From:
Sent: 29 November 2018 11:47
To:
Cc:
Subject: Objection to Application number 2018/62/93591/W - Castle Hill
Attachments: Castle Hill planning objection Nov 2018.docx

now objects to the grant of Outline Planning Permission for erection of a café/restaurant with bedrooms at Castle Hill, Huddersfield (Planning Application number 2018/62/93591), for the following “planning” reasons:-

Drawing
Proposed Site Plan

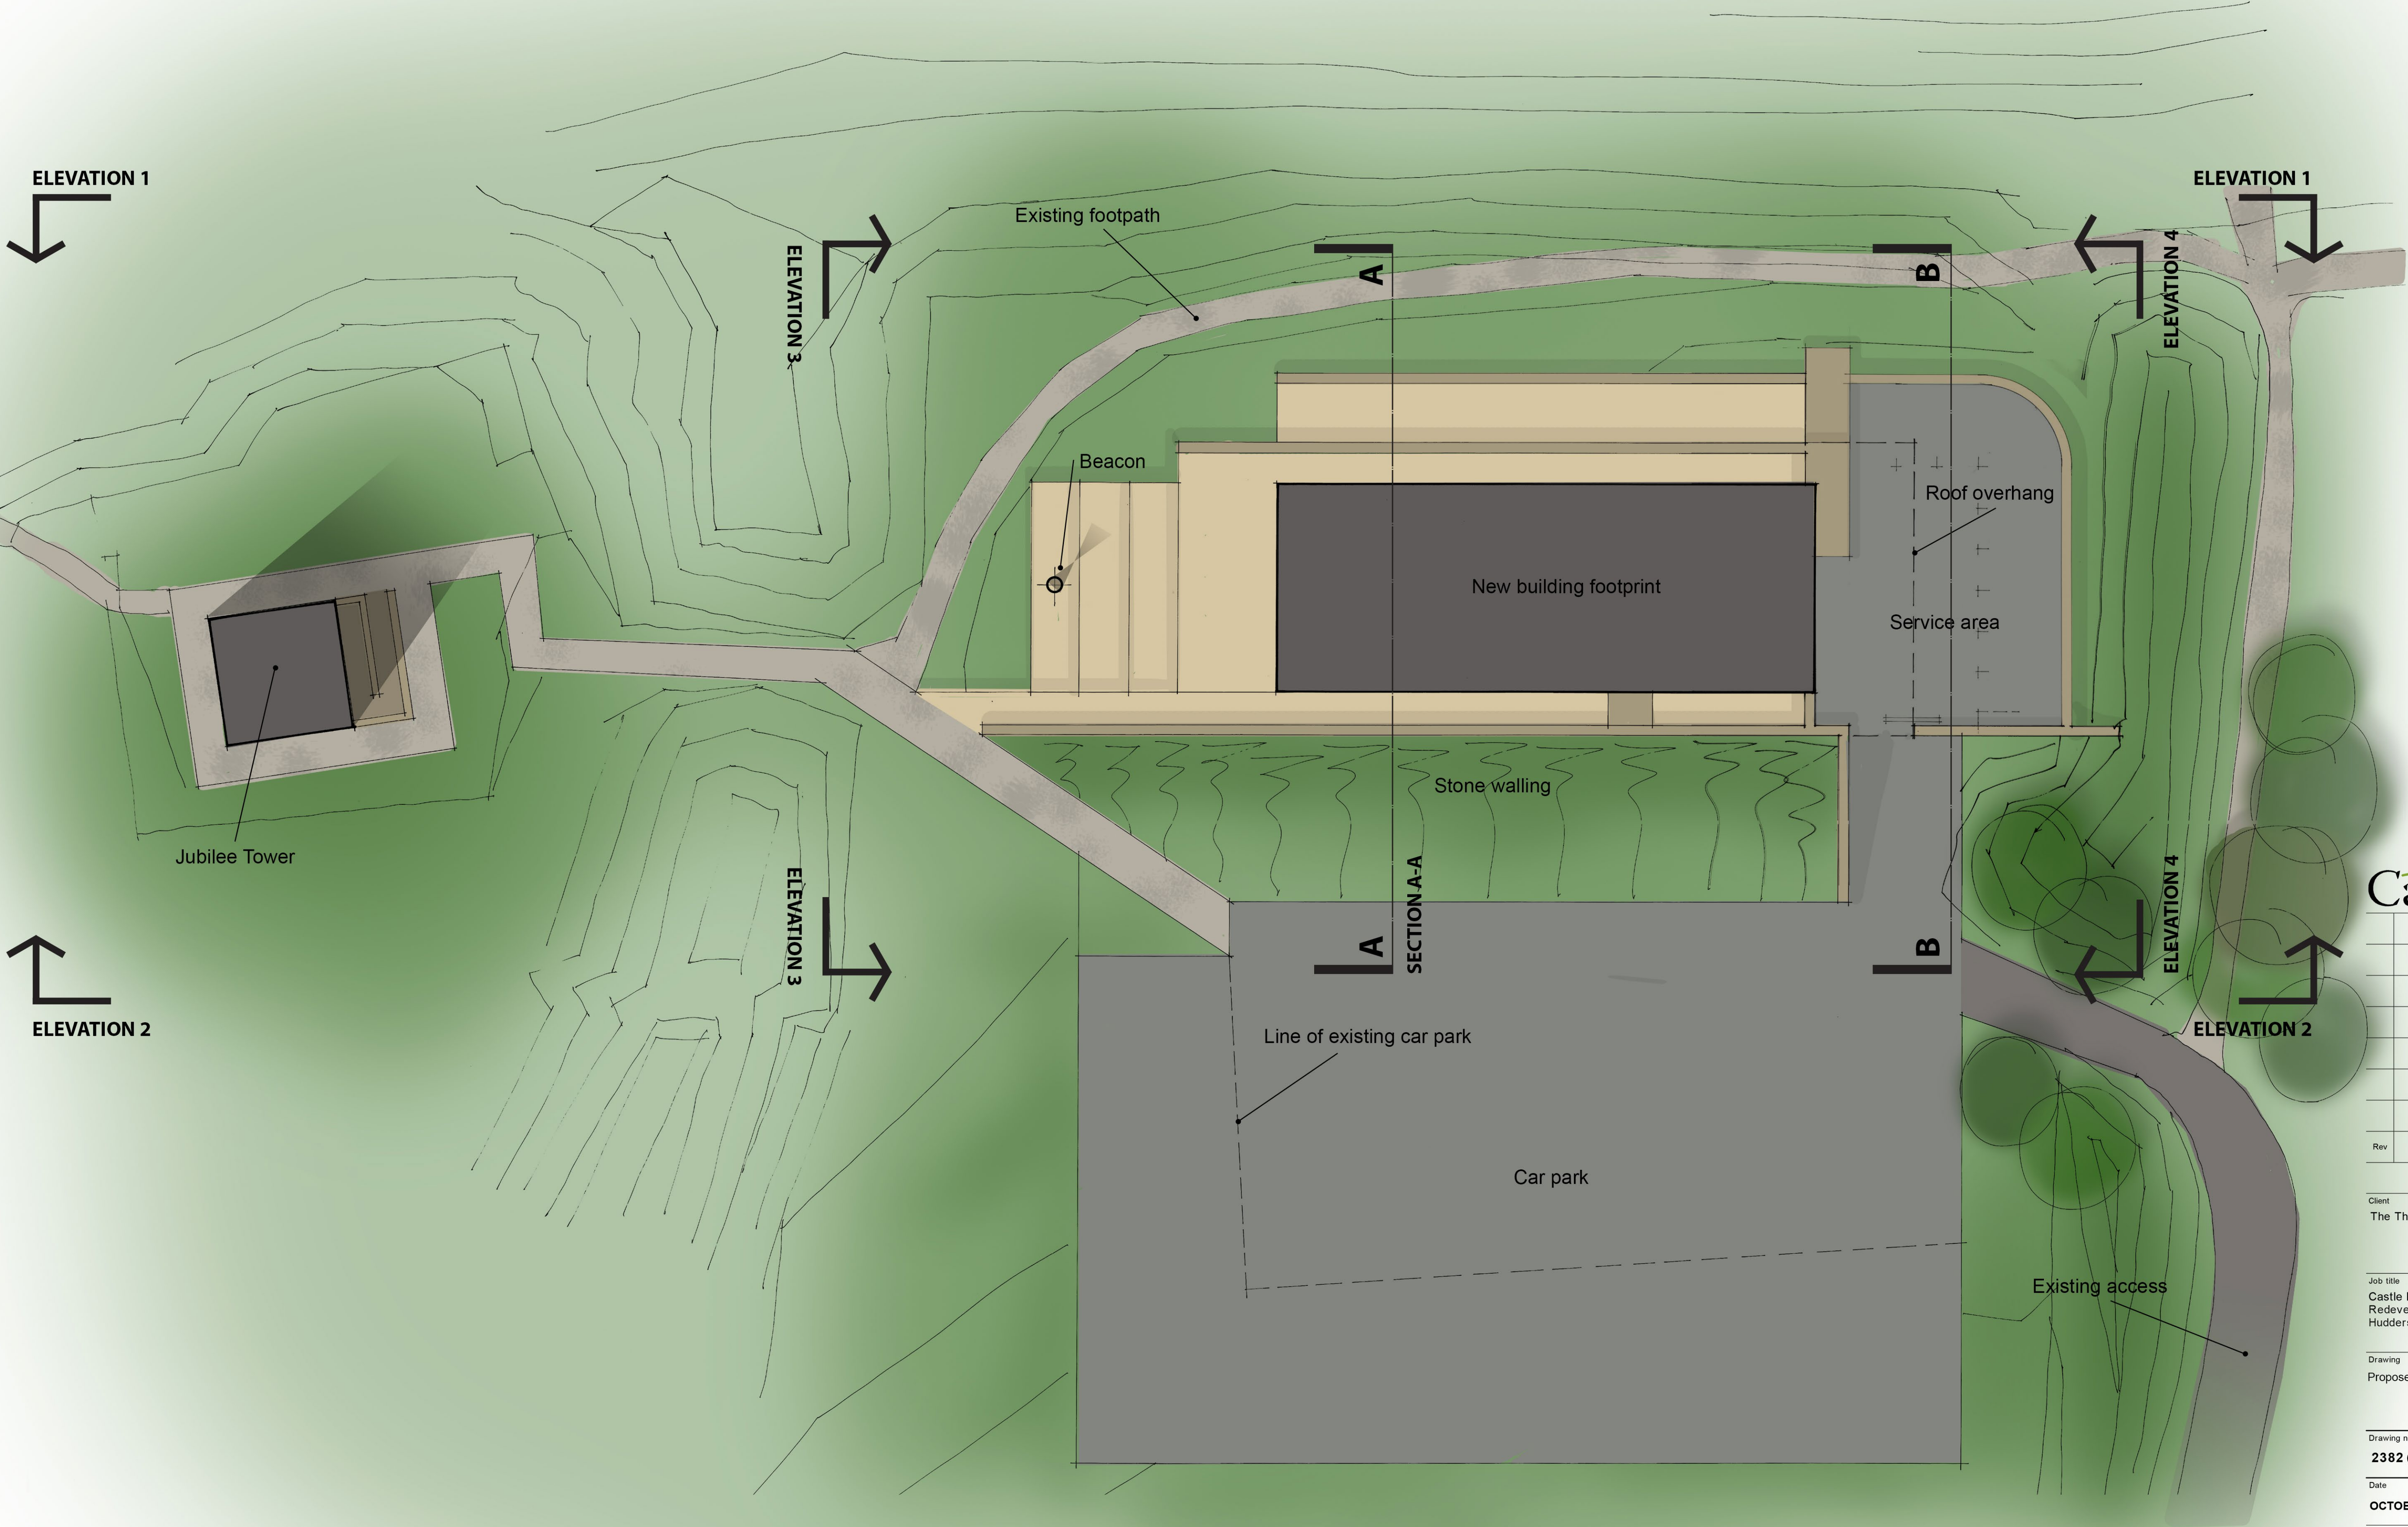
the hill. Visitors to Castle Hill will struggle to get any view of the tower, which is not dominated by the new facilities, from any part of the whole Castle Hill site. In turn, views over Castle Hill from the top of Victoria Tower will be overwhelmingly dominated by the new facilities, including large expanses of metal roof cladding and surfaced car parks. It will be almost impossible to visualise the full outline of the former motte and bailey castle, or the earlier hillforts, under the modern structures, car parks and roads.

- there is no provision for accommodation for either domestic or security staff in the plans (24/7?)
- The car park will have a paltry 28 places (less if you exclude handicap provision). Assuming two shifts a day and the fact that most employees will have to travel by car, this leaves precious few places for customers
- There is no sewerage provision
- There is no trade waste provision
- The wholesale use of tarmac is totally out of keeping with the site

INDICATIVE SIGNING AND LINING DETAIL

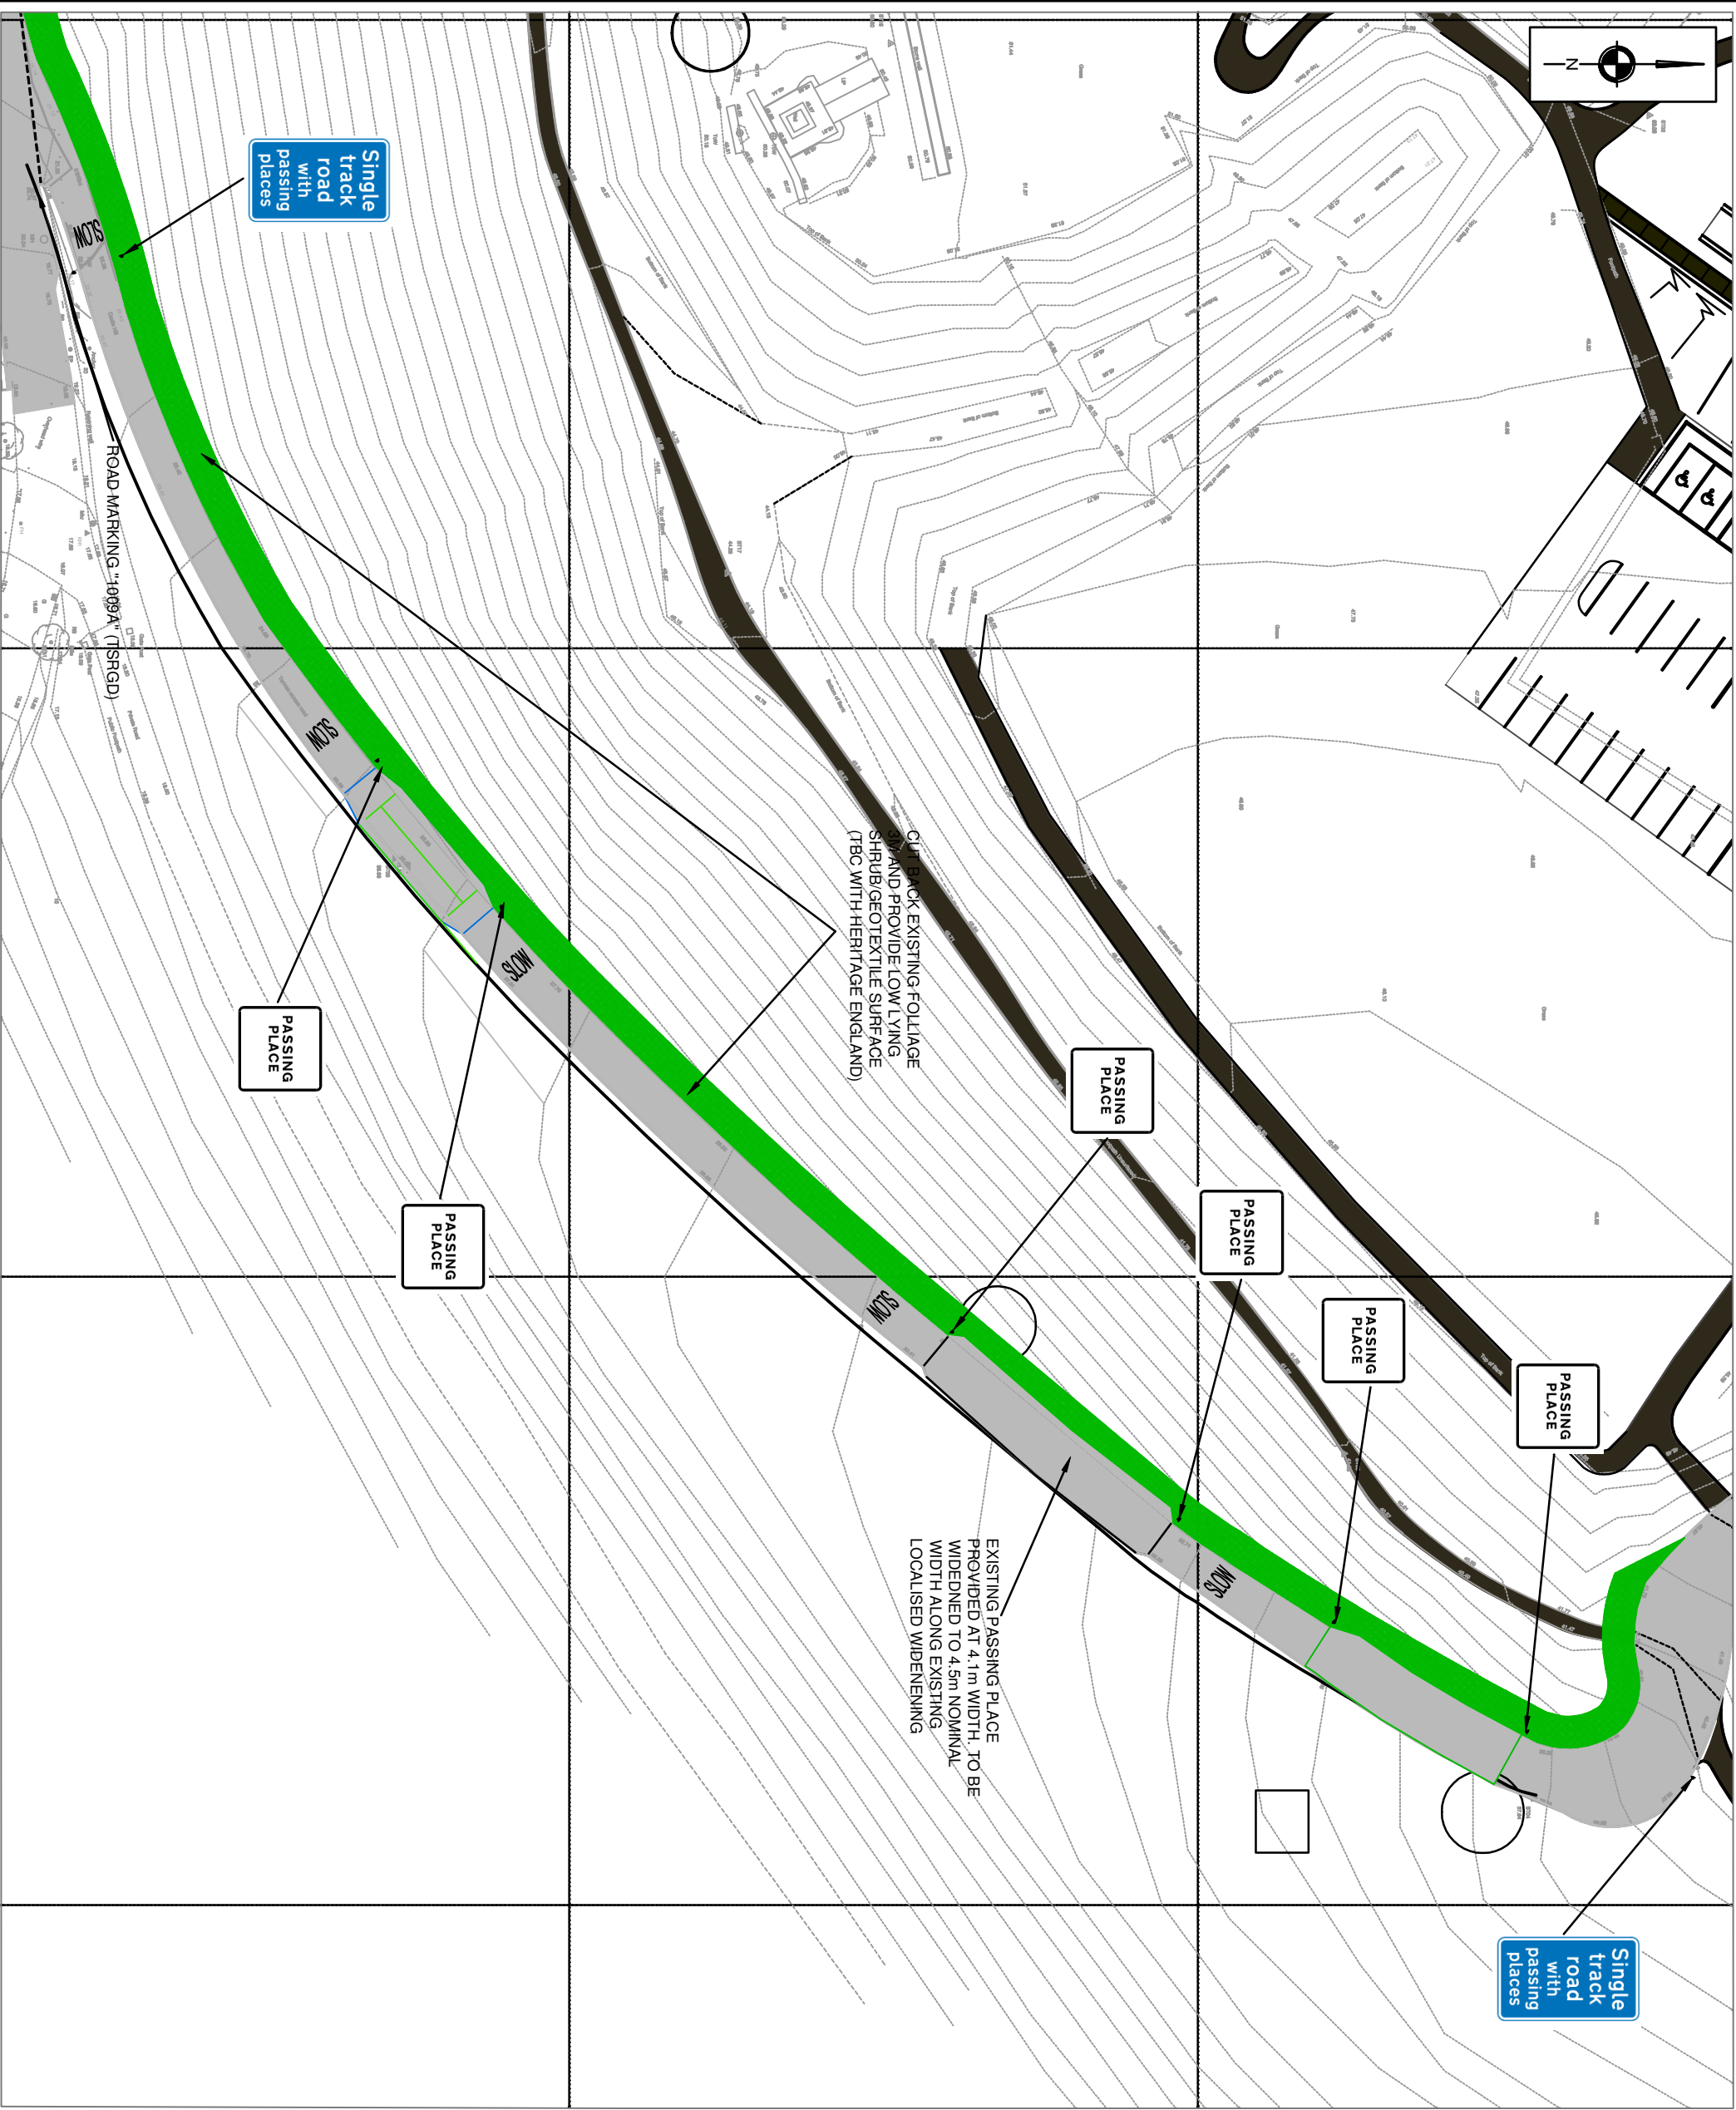
6. The access road to the site is grossly unsafe for ANY increase in visitor numbers (perhaps even unsafe for the smaller number of visitors who currently visit the site by car). The applicant’s proposals for a one-way traffic control system on the access road fail to address the underlying safety problems and are grossly inadequate for a “leisure” development of this scale and nature. NB: We believe that, due to the very steep gradients at 90 degrees to the line of the road, it is impossible to address the underlying safety problems of the current access road, without very significant earthworks, carriageway reconstruction, metal safety barriers and causing grossly unacceptable damage to the Southern flanks of the scheduled monument. The access road, as it stands, was built in the Victorian era and was never designed for motor vehicles, let alone the visitor numbers that would be necessary to economically sustain the proposed development.

It is quite clear that now, as in 2012, the access road to the top of the hill is completely inadequate for the traffic volumes that would be necessary to economically support the scale of the development. It has very steep gradients, tight (blind) bends and a narrow carriageway with a very limited number of passing places. It also has very steep slopes falling immediately away from the road verges in a Southerly direction with only very limited and totally inadequate wooden safety barriers, mainly at the sharp corner near the top of the road. There are very few roadside safety barriers for the other 95% of the road's length. Motorists and pedestrians share the only hard surfaced route to the top of the hill and there is no separate footpath or lighting whatsoever. Formalised pedestrian crossings near the top of the access road are unsigned, unlit and unsighted. With or without traffic controls the access road is quite simply unsafe for motorists and pedestrians alike, especially at night. We regret to say that the applicant's proposals for a one-way traffic control system will do little to address these fundamental highway use and critical safety issues. The access road is simply not suitable for a leisure development of this scale and nature. It is also difficult to see how it can be improved to a satisfactory standard without very substantial earthworks which would cause irreparable and unacceptable damage to the Southern flank of the hill itself and to the historic earthworks of the scheduled monuments. In our view the only viable permanent solution is to relocate the car park to the base of the hill, to completely relocate the access road to the less steep Eastern side of the hill, or both. The hill needs a new masterplan, perhaps a radical masterplan, if it is to overcome this major obstacle.

Job Title Castle Hill, Huddersfield	
Client The Thandi Partnership	
Status Planning	Company AD
Drawing Proposed Elevations Sheet 2 of 1:200 2	
Date October 2019	Drawn / Checked FWG
Drawing No. 3267 (0-) 09	Revision -

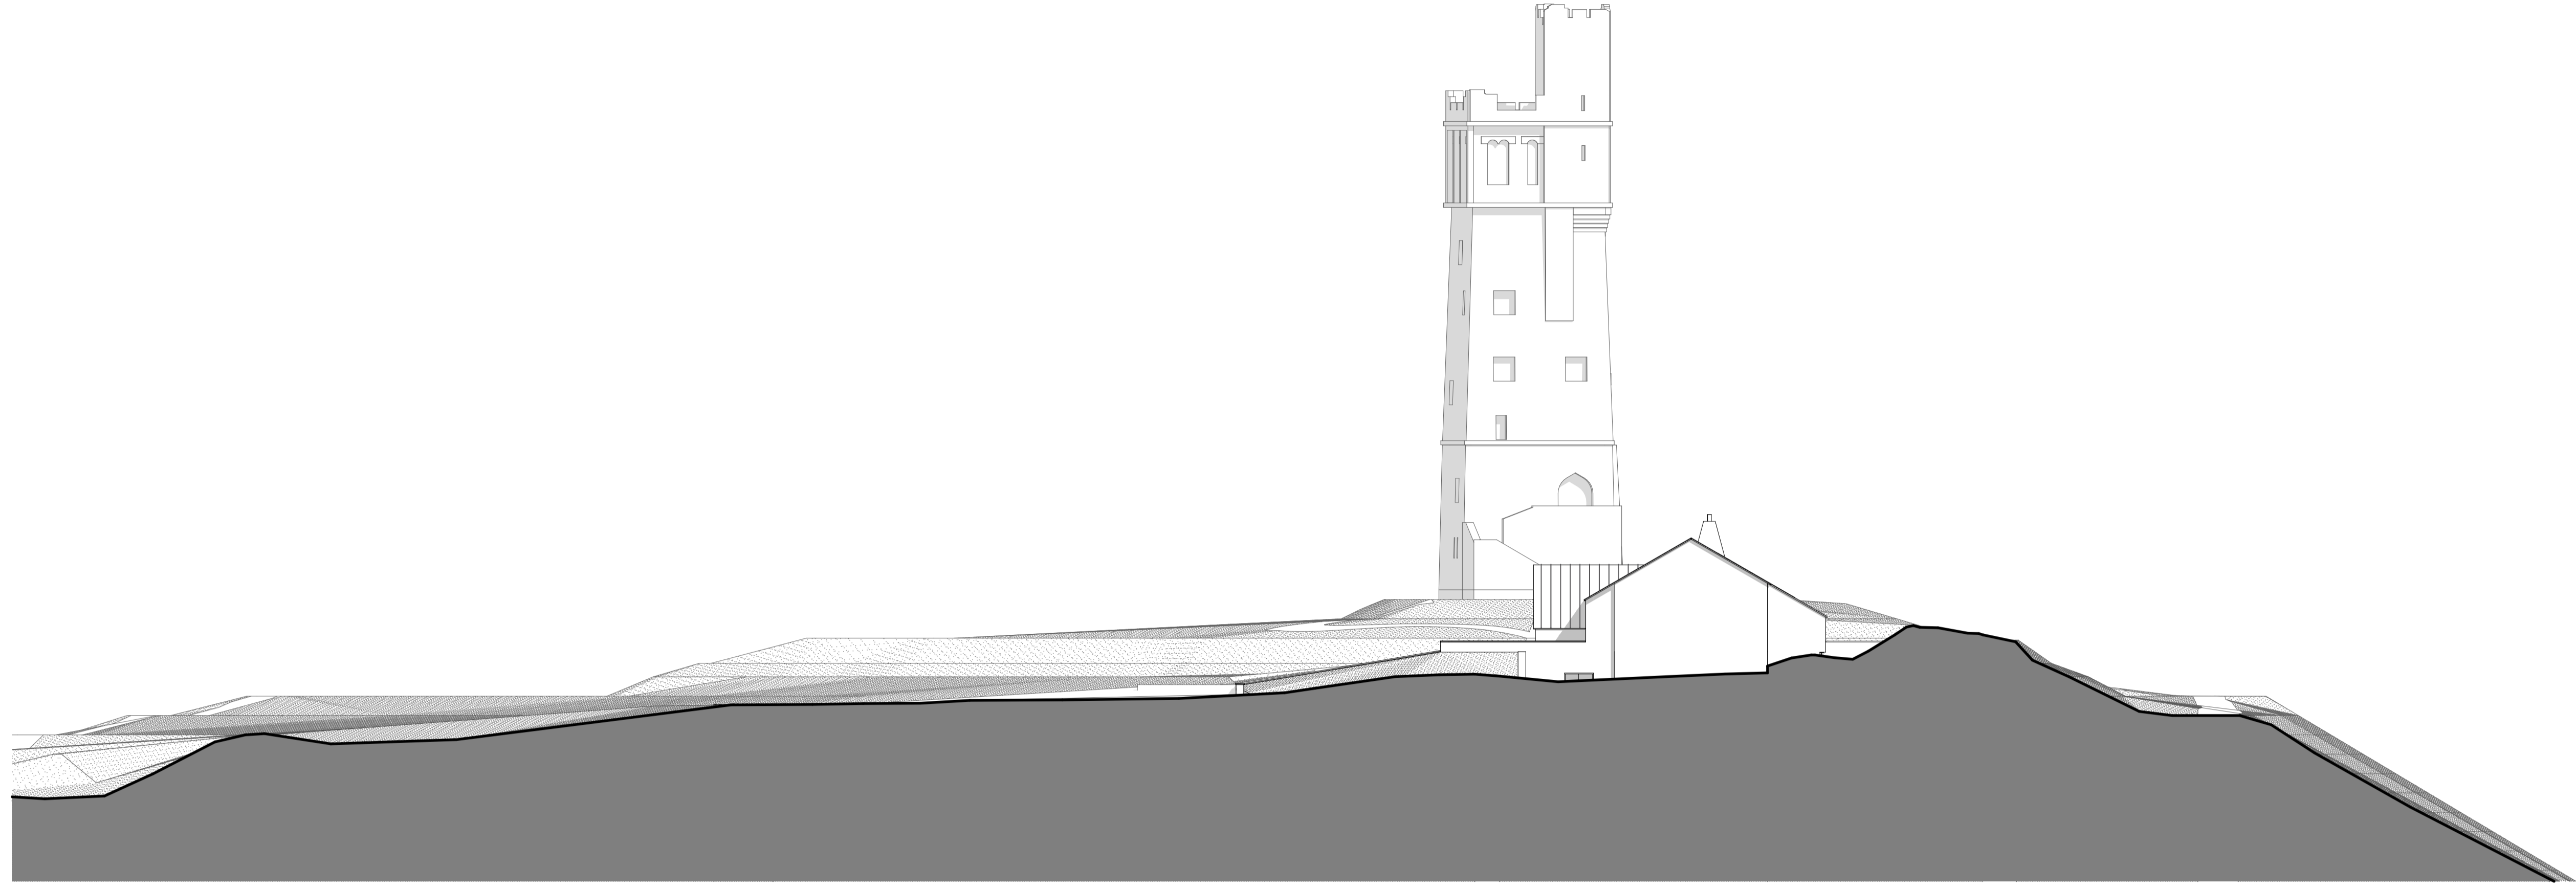
Although the new proposals adopt a slightly lower profile than the design refused in 2012 they still rise above the natural hill profile and present an unnatural “hard” edge against the skyline from all sides, but particularly from the north and south elevations. In fact the glass wall cladding, continuous curve of the roof elevation and the very large area of metal (e.g.zinc) roofing material all serve to emphasise how alien the proposed structure is to the hill and the green belt setting. We strongly disagree with the developer that the profile of the structure will be reminiscent of a natural Pennine hill. In our view, the architectural design of the new facilities does not complement the hill or the tower at all and in many ways is more reminiscent of a world war two aircraft hangar. (Others have likened it to a cheap cost-cutting supermarket). It will stick out like a sore thumb from many miles away and there will be very significant harm to the openness of the green belt and the setting of the heritage assets on the hill.
